Transport
for NSW

**Kariong Sand and Soil Supplies Facility (SSD-8660)
Amended Environmental Impact Statement and Response to Submissions Report**

CD20/06995

SHEET:	110	DATE:	07/04/2020
SHEET No:	5 OF 9	SIZE:	A1
SCALE:	1:750	DATUM:	AHD
COORD. ORIGIN:

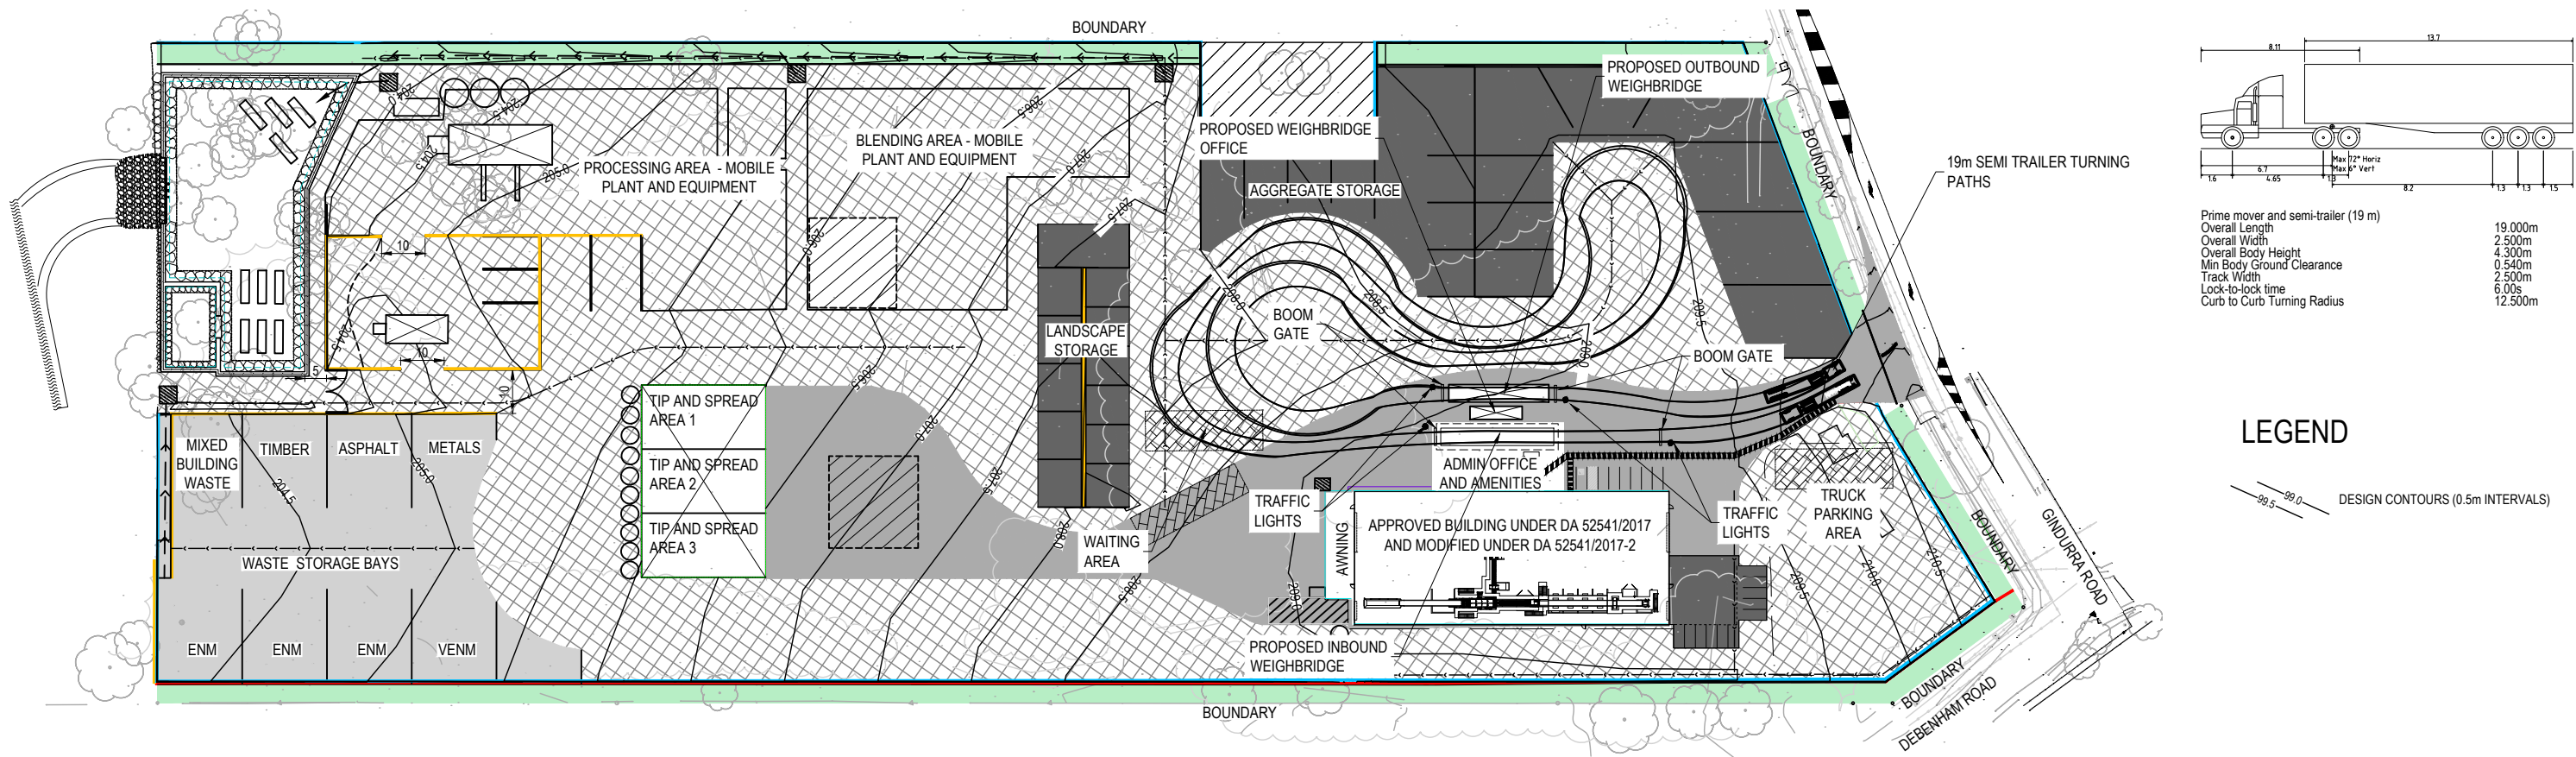
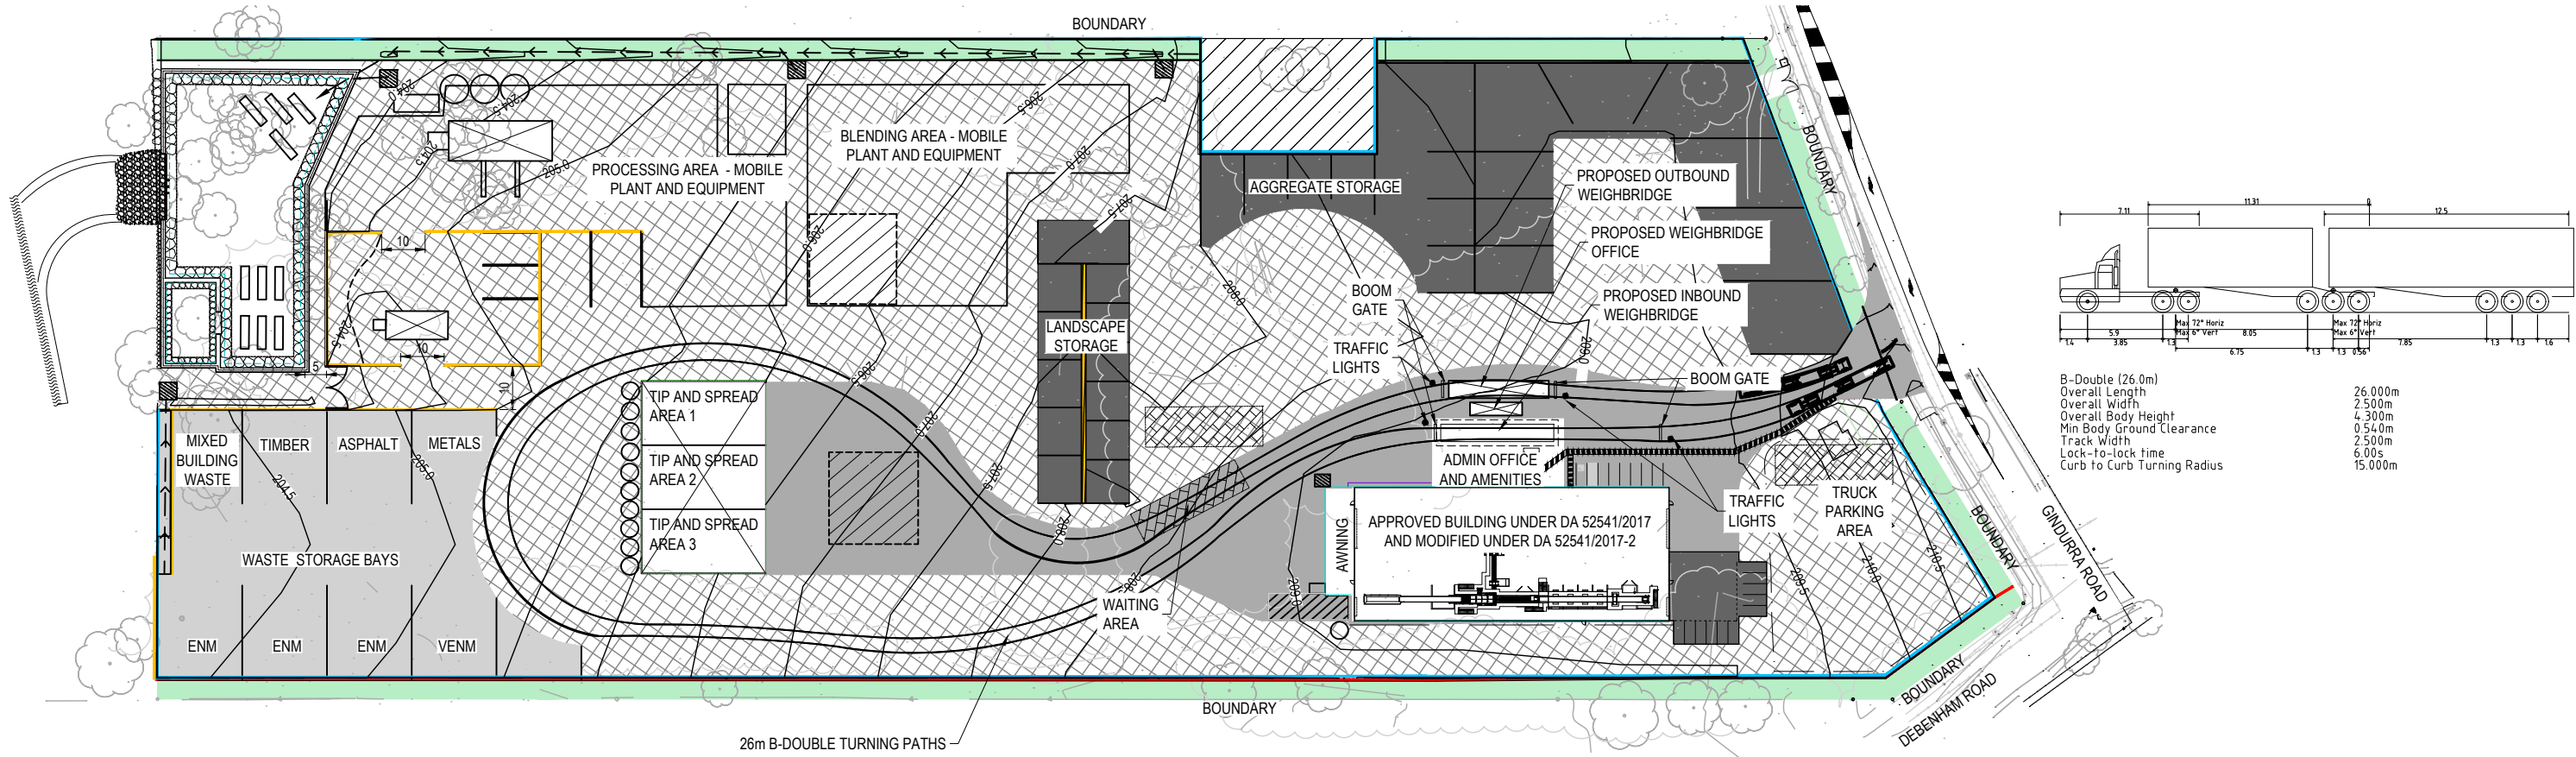
The documents on exhibition associated with the subject matter have been reviewed and no further issue is raised to the proposal. As noted in our previous submission, it is advised that the proposed right turn treatment on Gindurra Road at the site access be designed in accordance with the current versions of Austroads Guide to Road Design Part 4 and Part 4A.
